From: Richard Castro-Parker
Sent: 04 March 2019 16:19
To: Planning.Responses
Subject: FW: M/1/19/NMA - 25 Sea Way, Middleton on Sea.
Attachments: Prop Roof Plan 1.pdf

Subject: M/1/19/NMA - 25 Sea Way, Middleton on Sea.

PROPOSED SECOND FLOOR PLAN

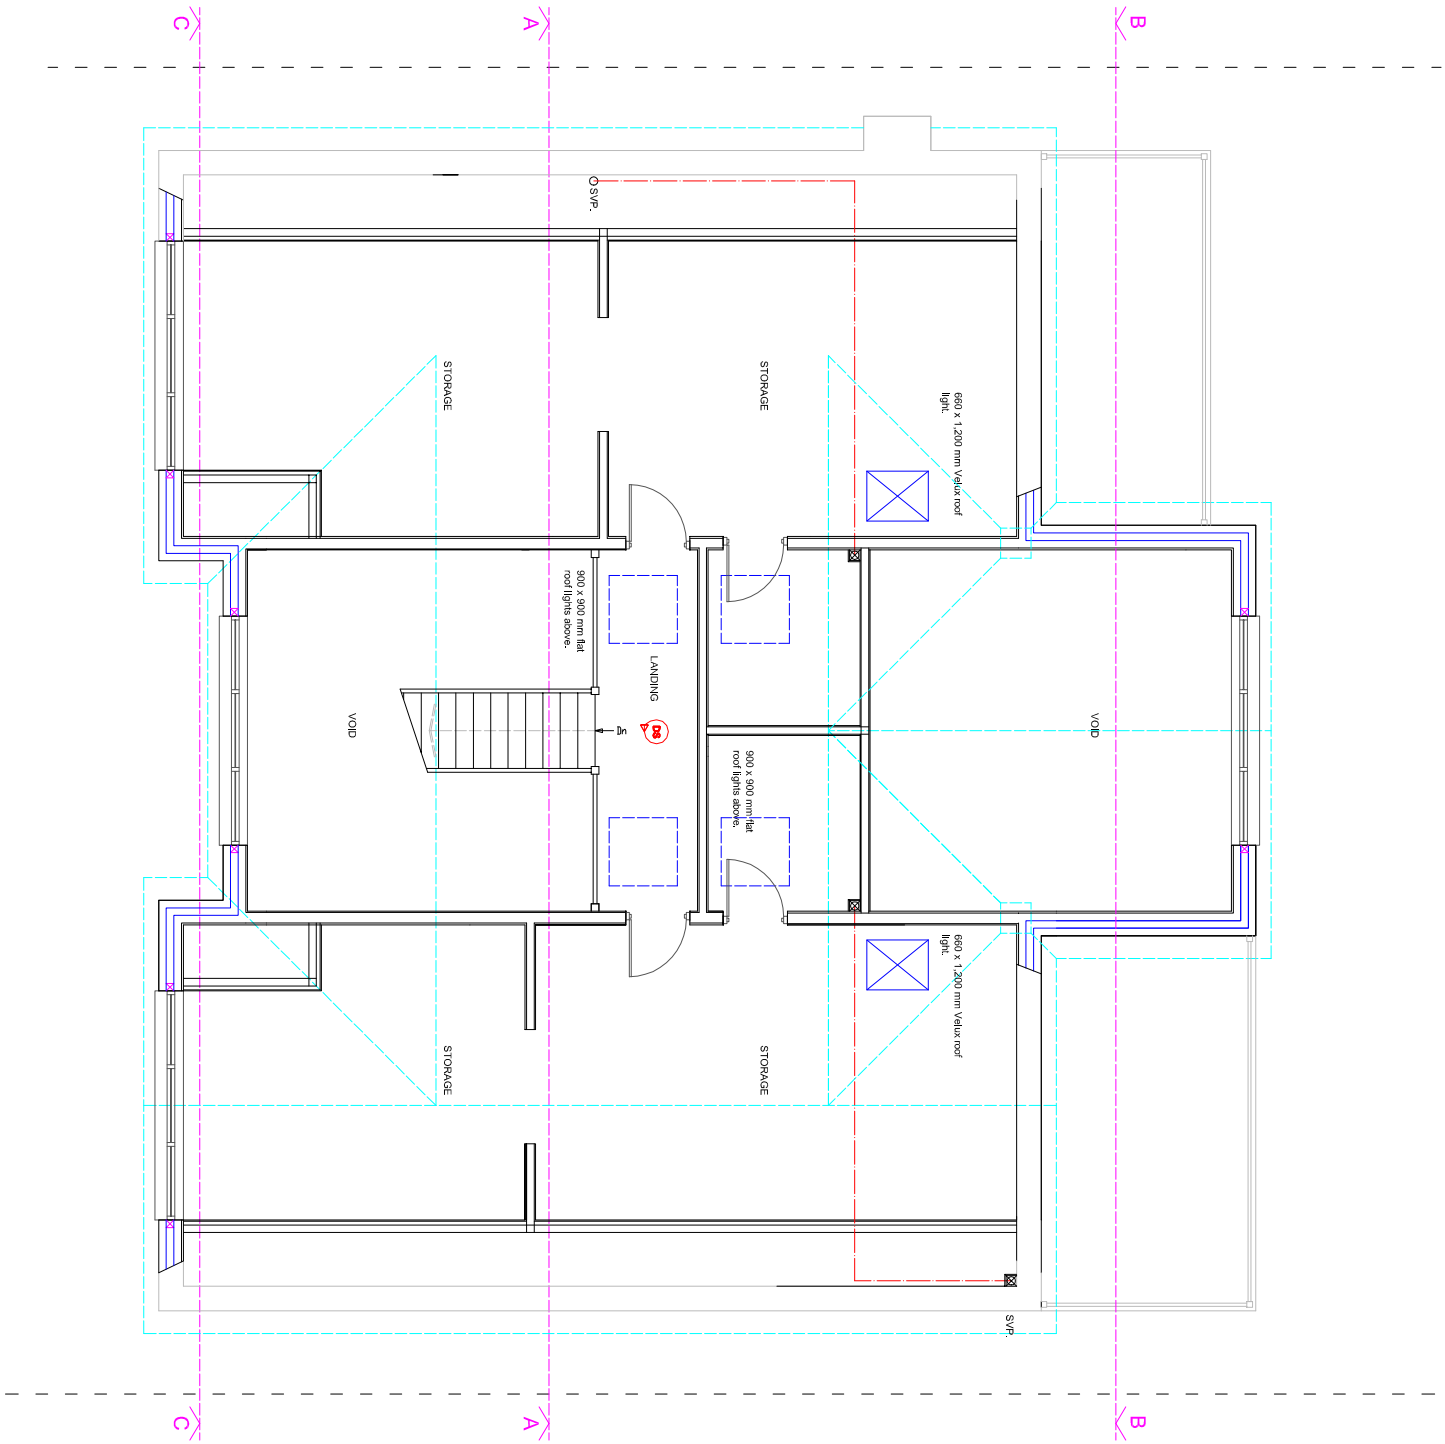
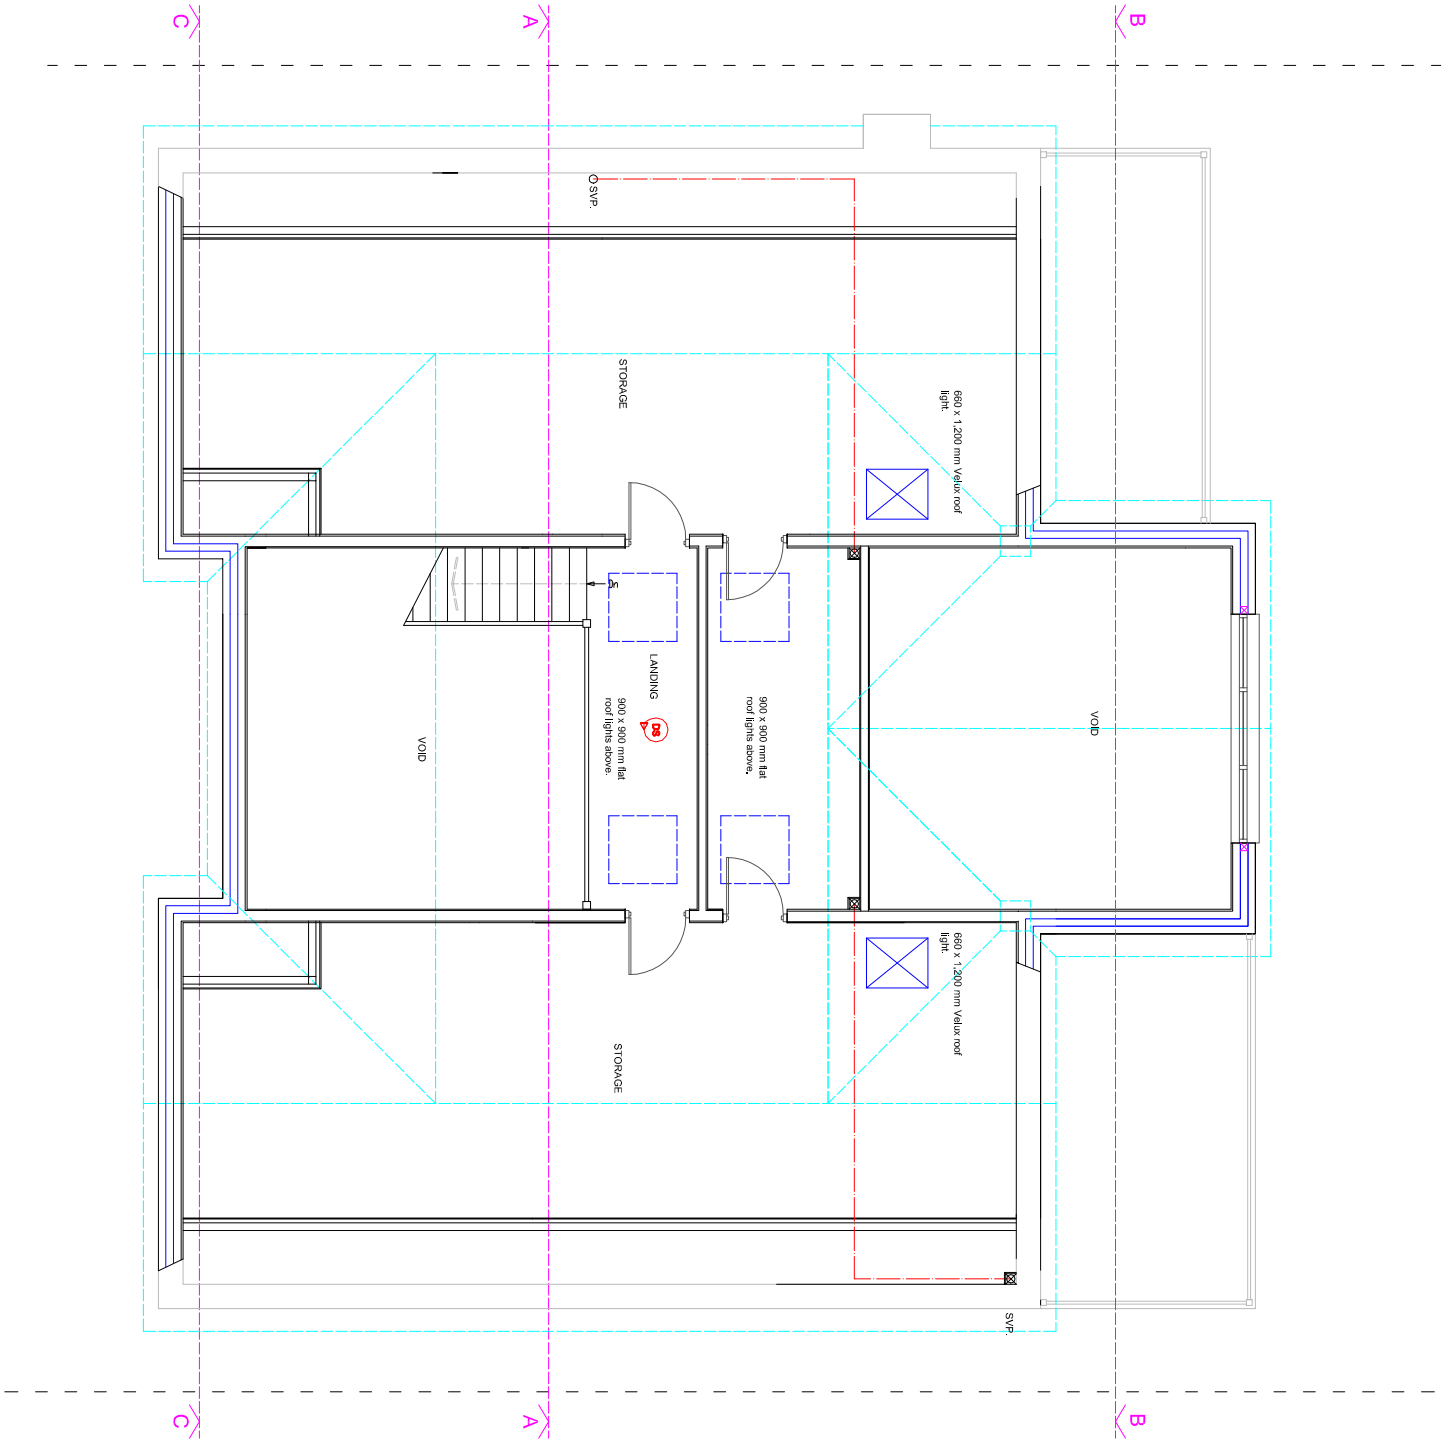
I refer to the above application and I have seen that you left a message for me yesterday. You have mentioned the fact that the submitted second floor plan shows the windows (in error) to the front facing elevation.

You have asked this question before and I have already sent you revised plans by email on 8th February and again on 14th February (after you asked again), correcting the error.

I once again attach a copy of the revised second floor plan and the front facing elevation for substitution for those you are wrongly showing on the current application.

PROPOSED ROOF PLAN

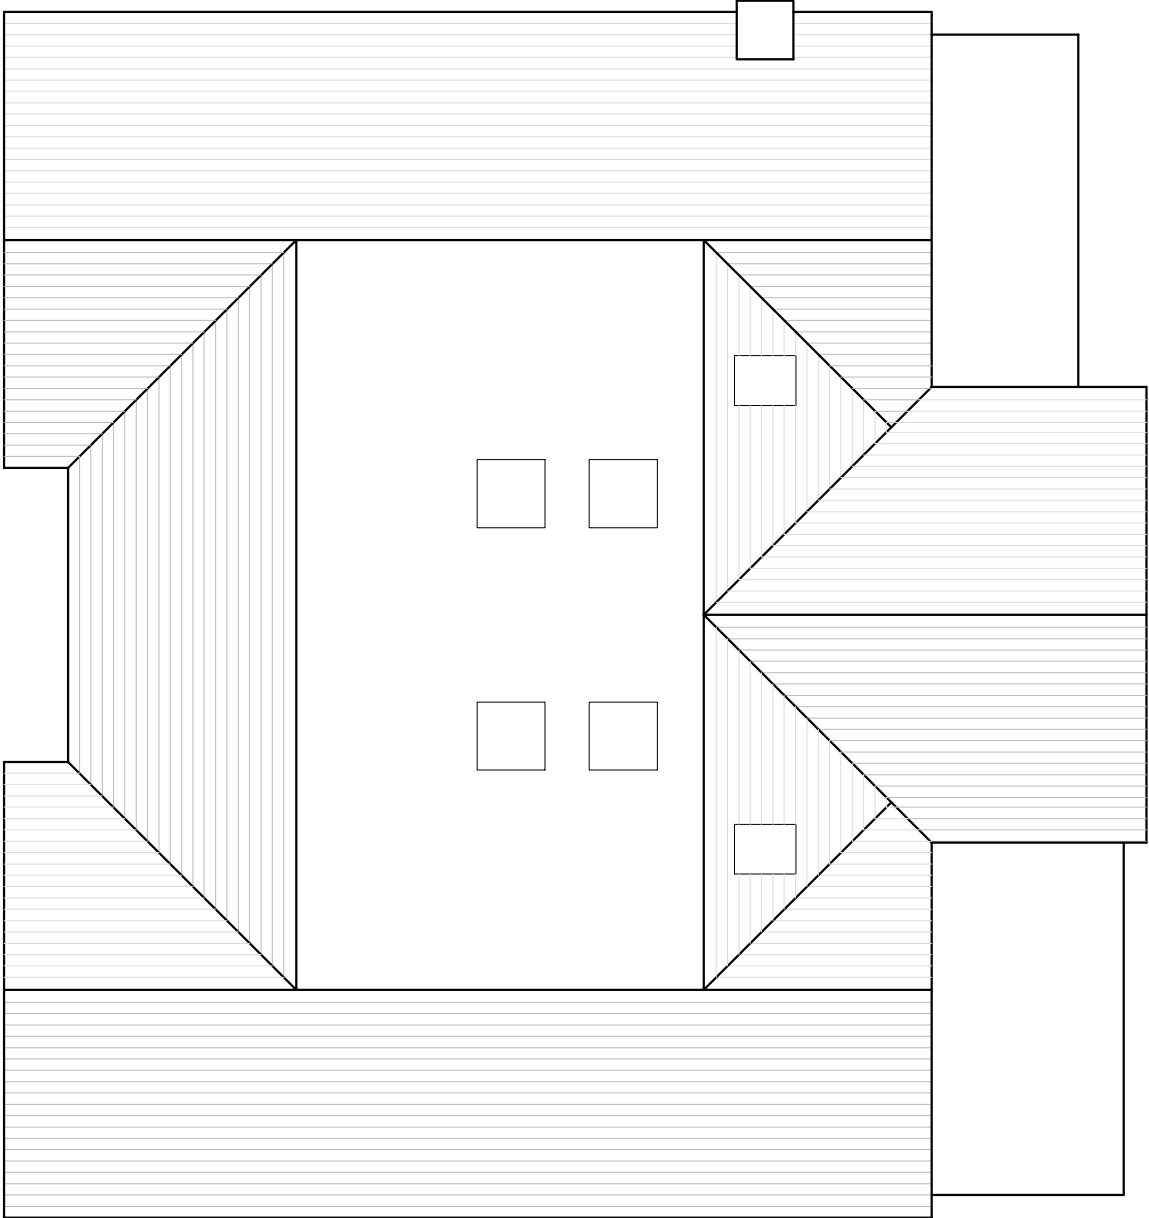
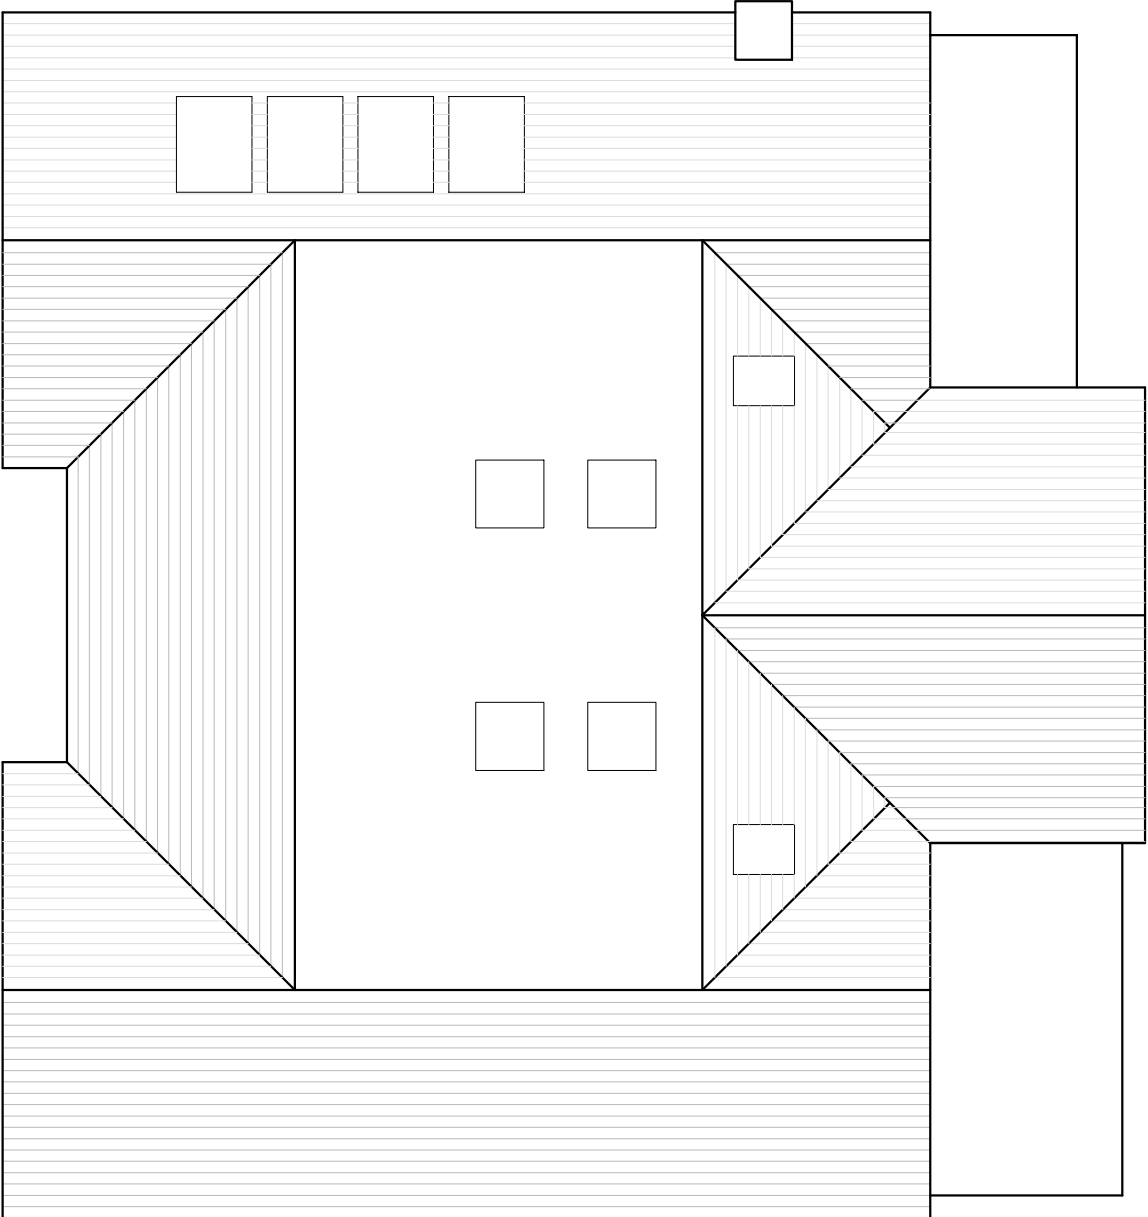
I have written the NMA application for approval (as per the amended plans). I note that solar panels are shown on the Proposed Front/Side Elevation Plan (as amended). However, an amended roof plan showing the proposed solar panels has not been provided. Please could you provide an amended roof plan including the proposed solar panels and I can then pass the application for Manager sign-off.

Updated roof plan attached as requested.
